Arun District Council
Arun Civic Centre
Maltravers Road
Littlehampton
West Sussex BN17 5LF
Planning & Building Control General Enquiries
Tel: (01903) 737756 Fax: (01903) 730442
Dx: 57406 Littlehampton
Minicom: 01903 732765
e-mail: planning@arun.gov.uk
website: www.arun.gov.uk/planning

Application No: AW/159/21/HH
Site Address: 25 The Drive Aldwick PO21 4DU
Description of works: Loft extension with 3 x rear dormers. This application affects the setting of the Craigwell House Conservation Area.

Thank you for your internet representation made on 30th May 2021 which has been recorded as an objection with the comments as follows:

| Drawing number<br>AP/25/21/02 | Rev |

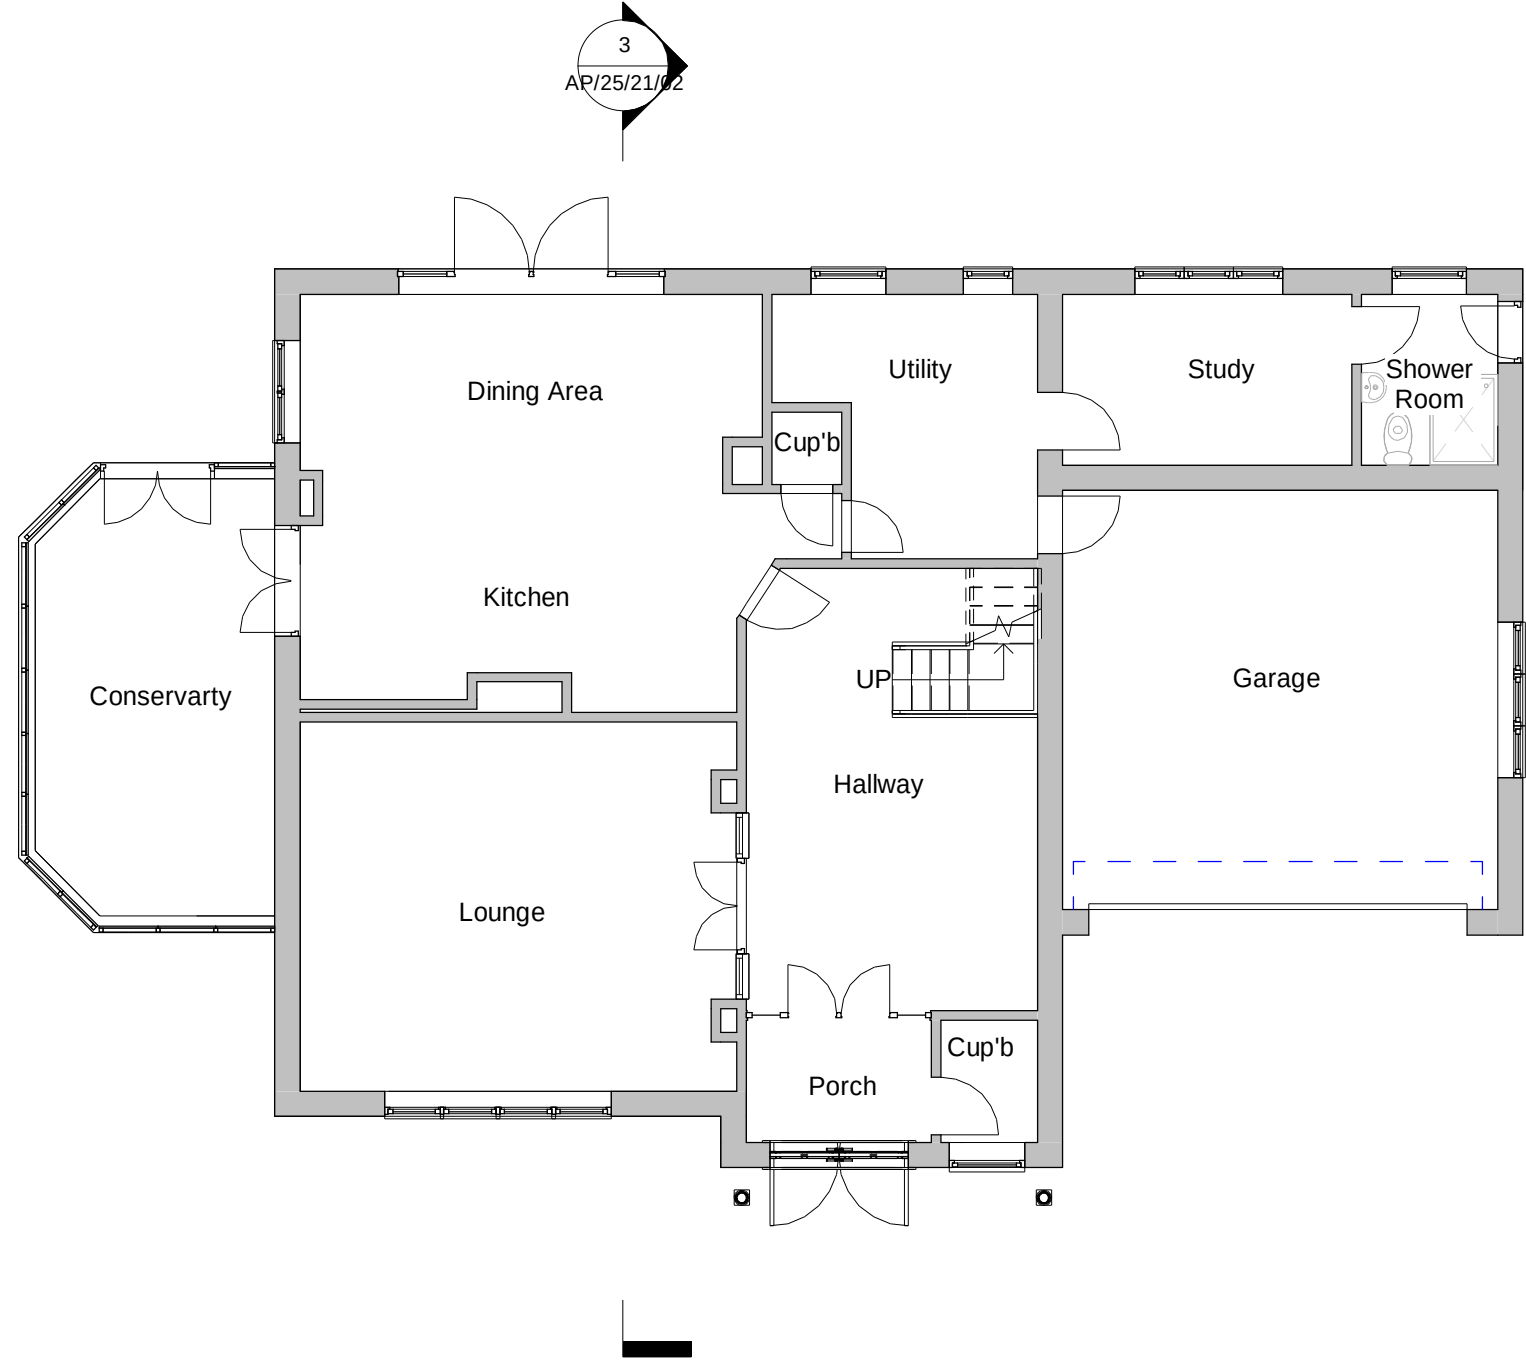
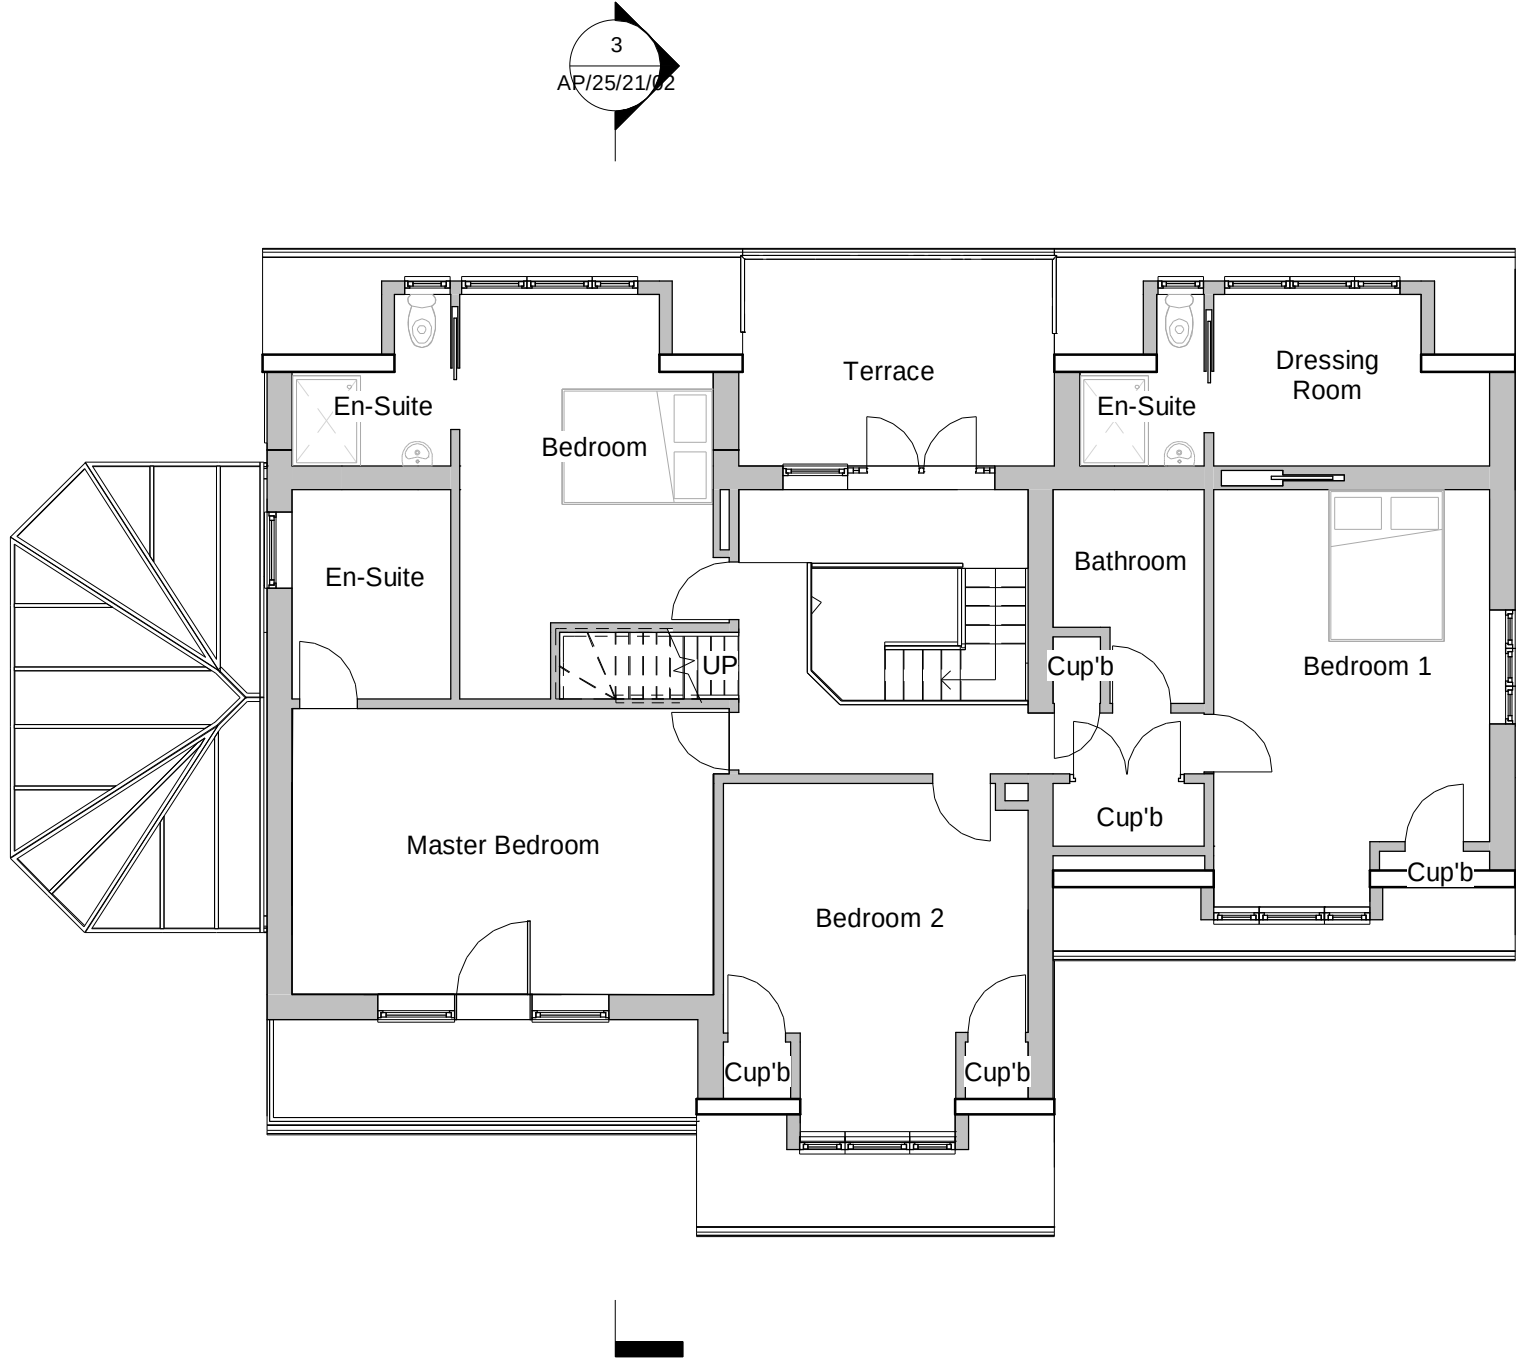
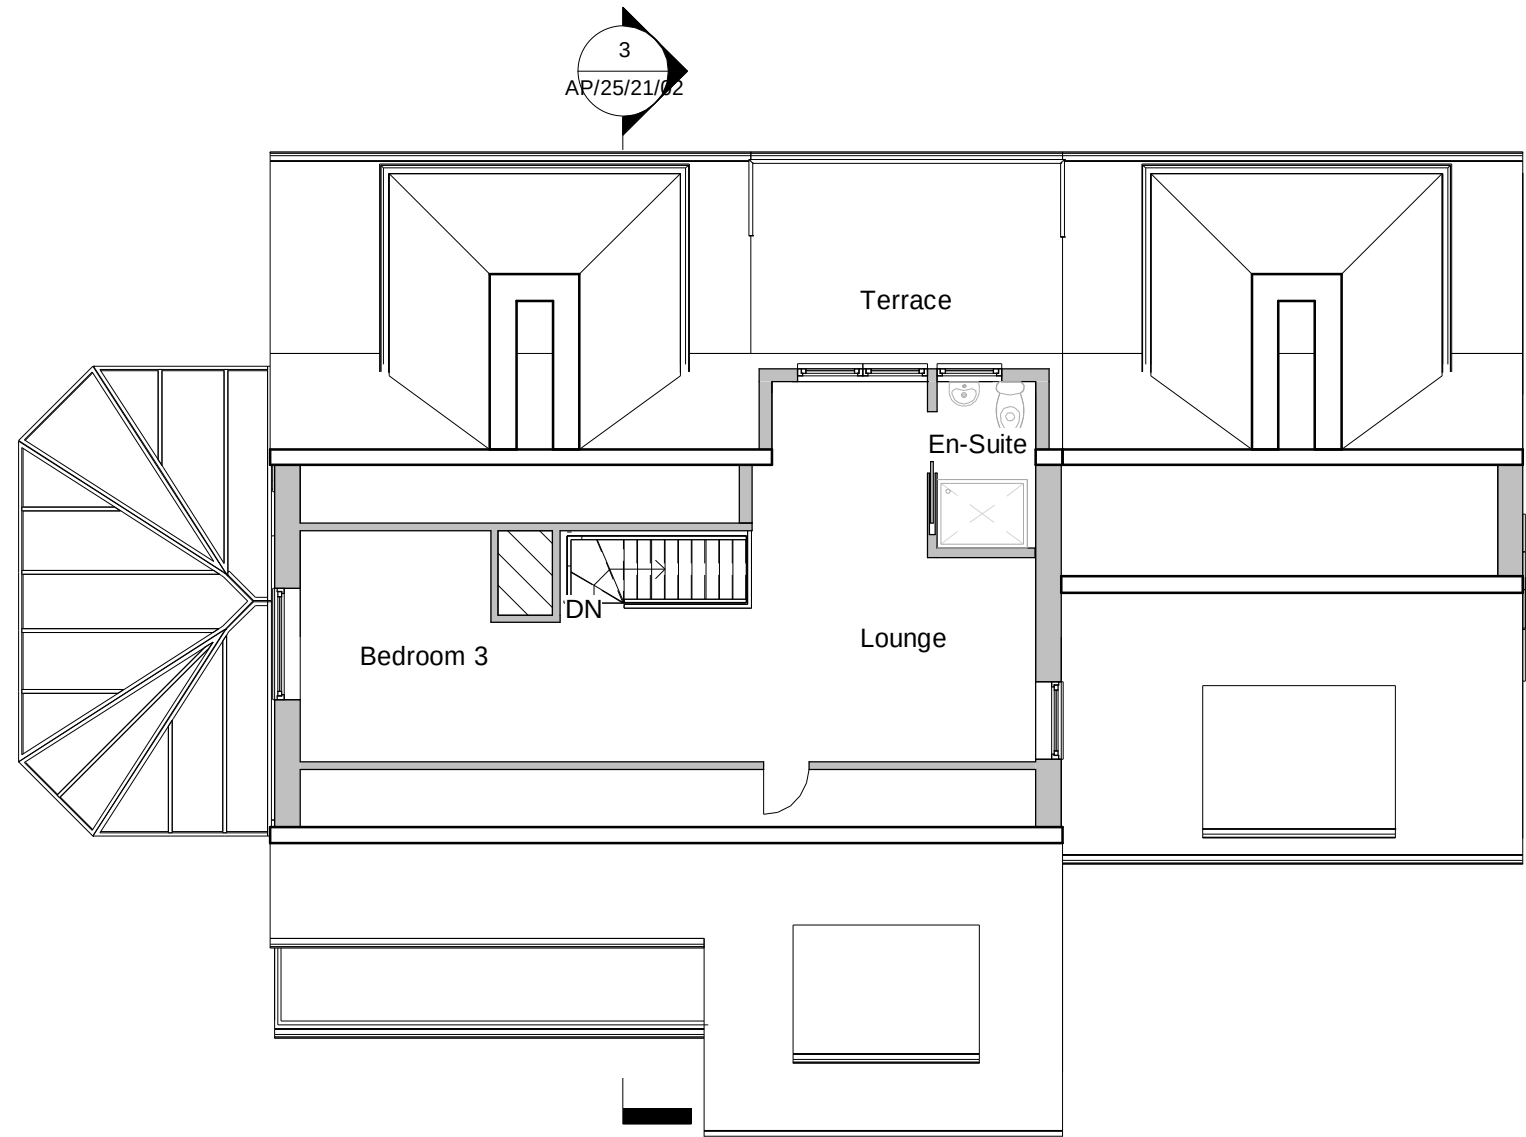
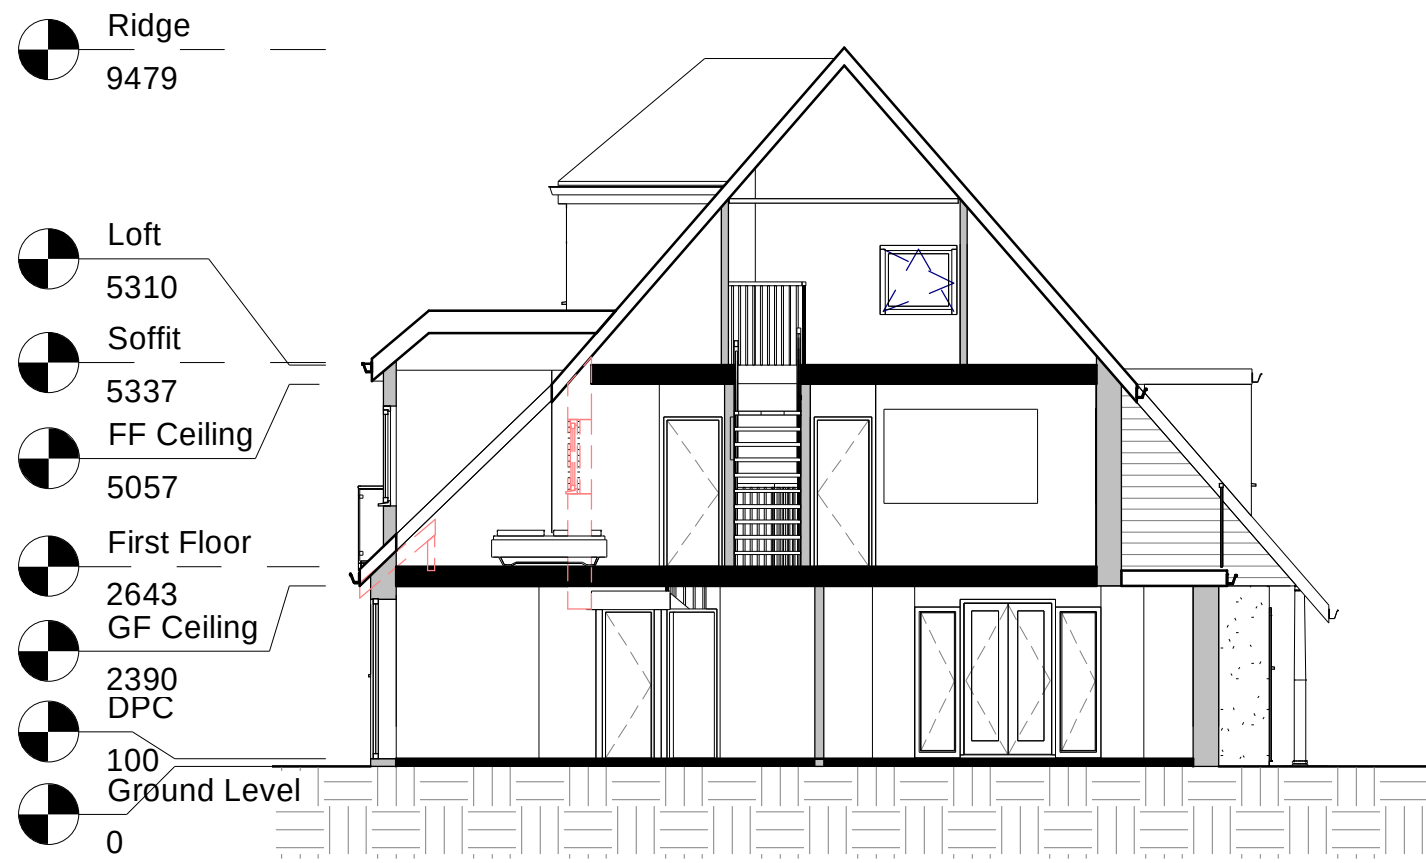
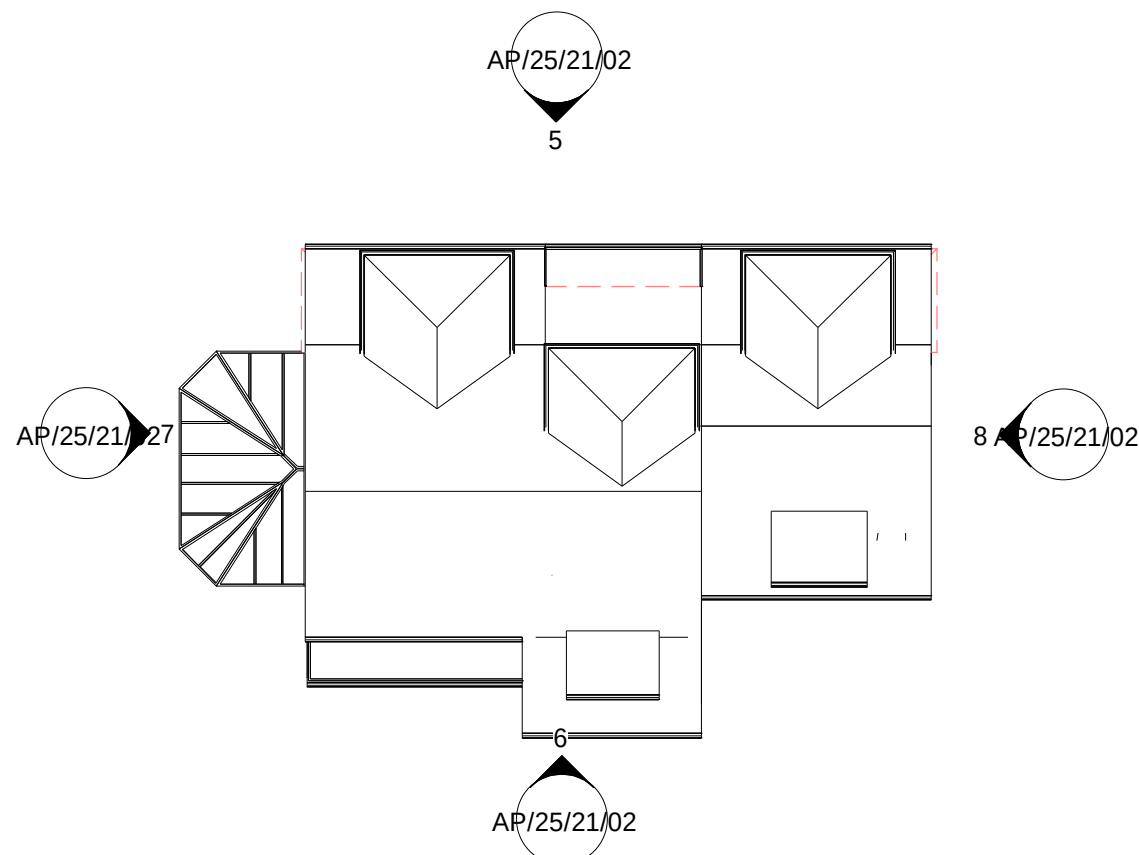
The proposed changes and specifically the proposed dormer window (Rear Elevation - North) in the loft space as shown on proposed plans AP/25/21/02 has direct line of sight view on all aspects of the rear facing property at 22 Kingsway and most of the rear garden.

I object to this planning permission on the grounds that the proposed development will be will result in a loss of privacy.

The Craigweil Private Estate is within a conservation area and this will have a significant impact on the privacy of both ourselves and those living in the neighbouring properties at numbers 23 and 27 The Drive.
